RE: West Wyalong Solar Farm (SSD 9504) – Exhibition of Environmental Impact Statement

I refer to your email dated 8 February 2019 to the Office of Environment and Heritage (OEH) seeking comment on the Environmental Impact Statement (EIS) for the proposed West Wyalong Solar Farm (SSD 9504).

ATTACHMENT A – OEH Assessment Summary for West Wyalong Solar Farm (SSD 9504)
ATTACHMENT B – Detailed comments for West Wyalong Solar Farm EIS (SSD 9504)

Figure 9.1: Location of Aboriginal sites in relation to the proposed solar farm layout (REV 15)

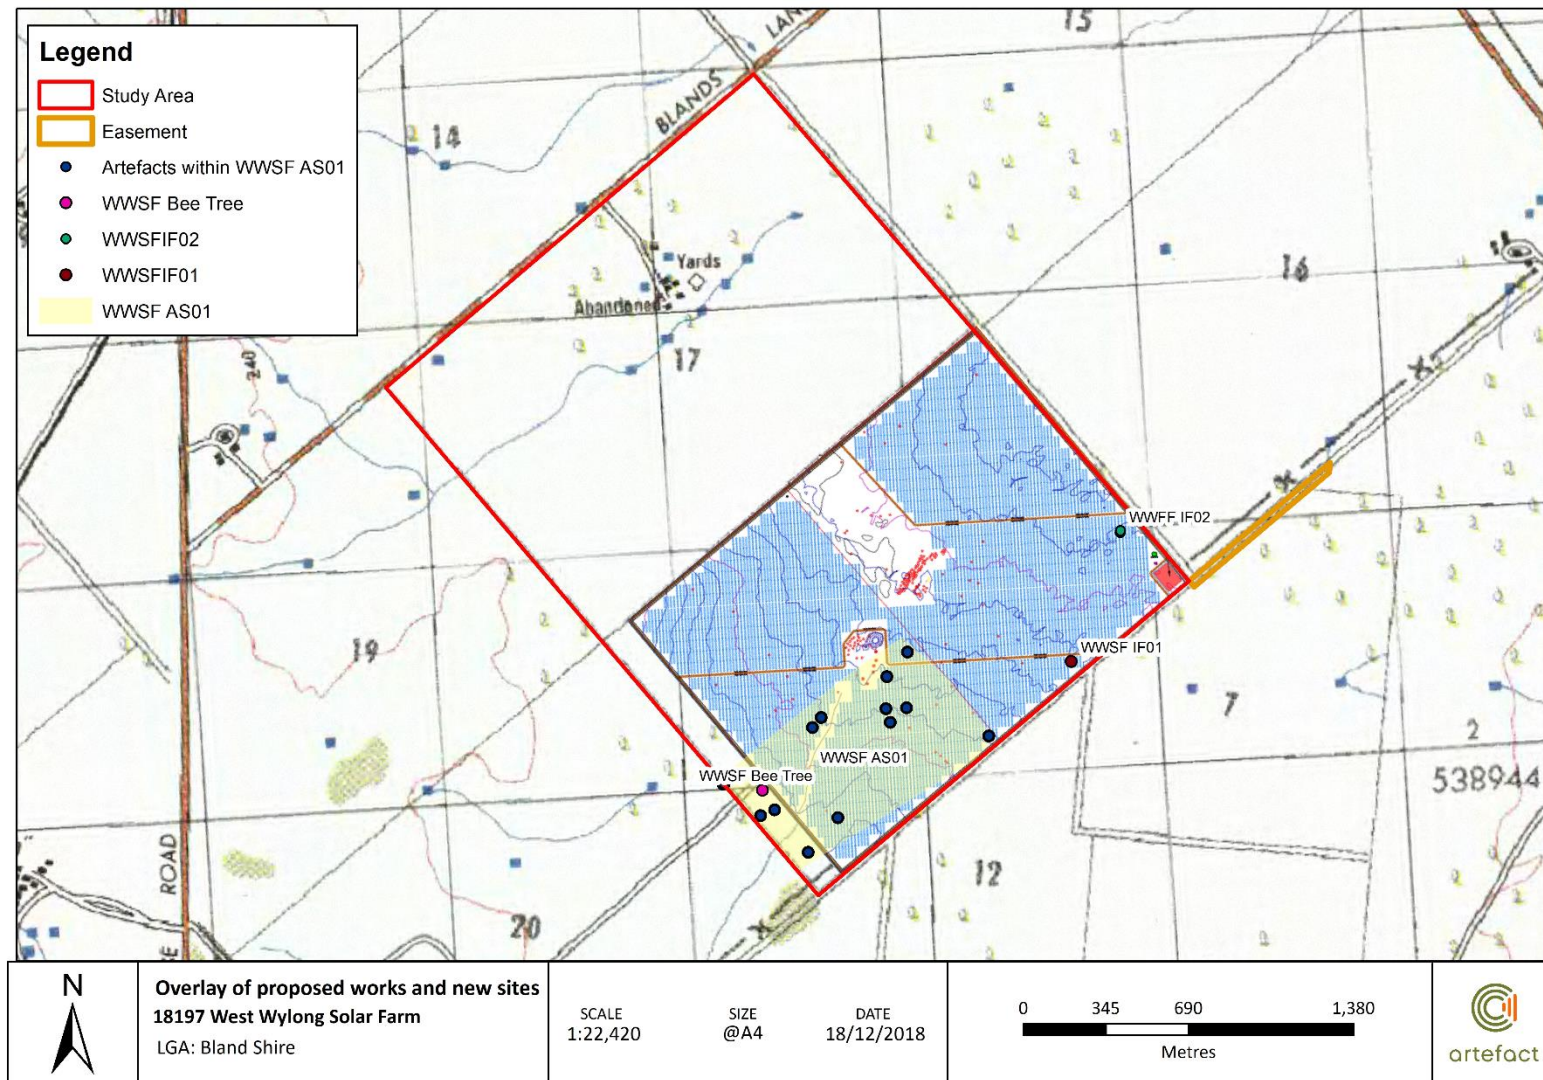
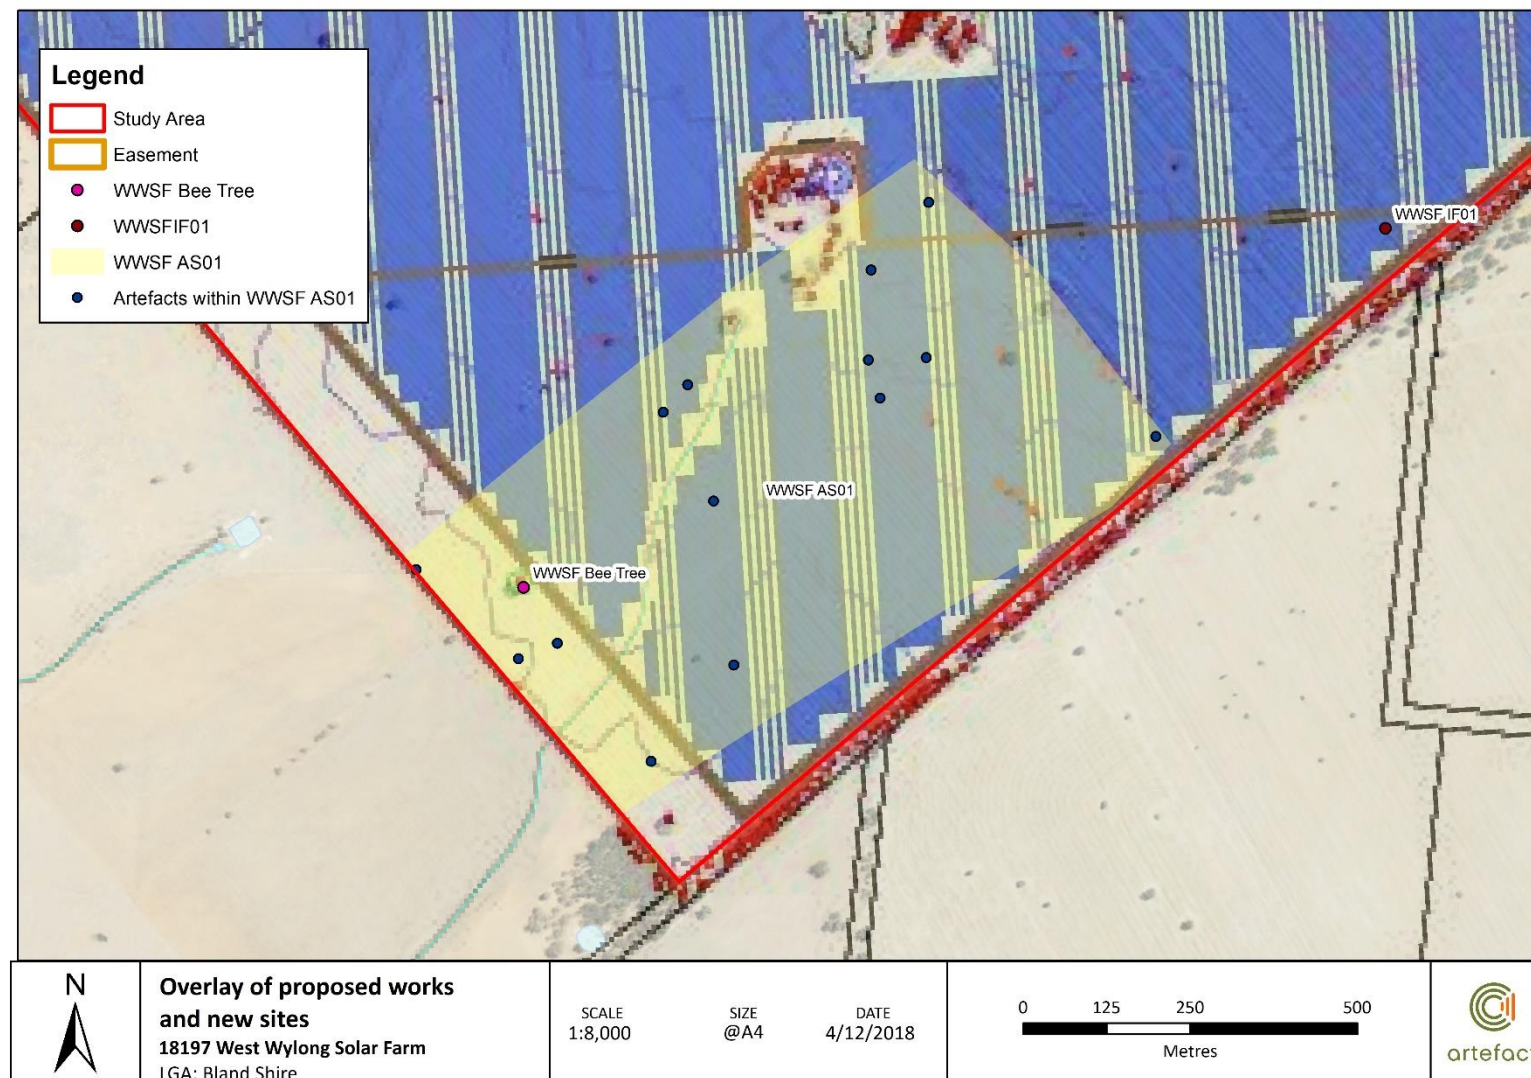
Management of WWSF Bee Tree and part of WWSF AS01

The site WWSF Bee Tree (43-4-0058) and part of site WWSF AS01 (part of 43-4-0057) are to be conserved and protected through fencing and signage.
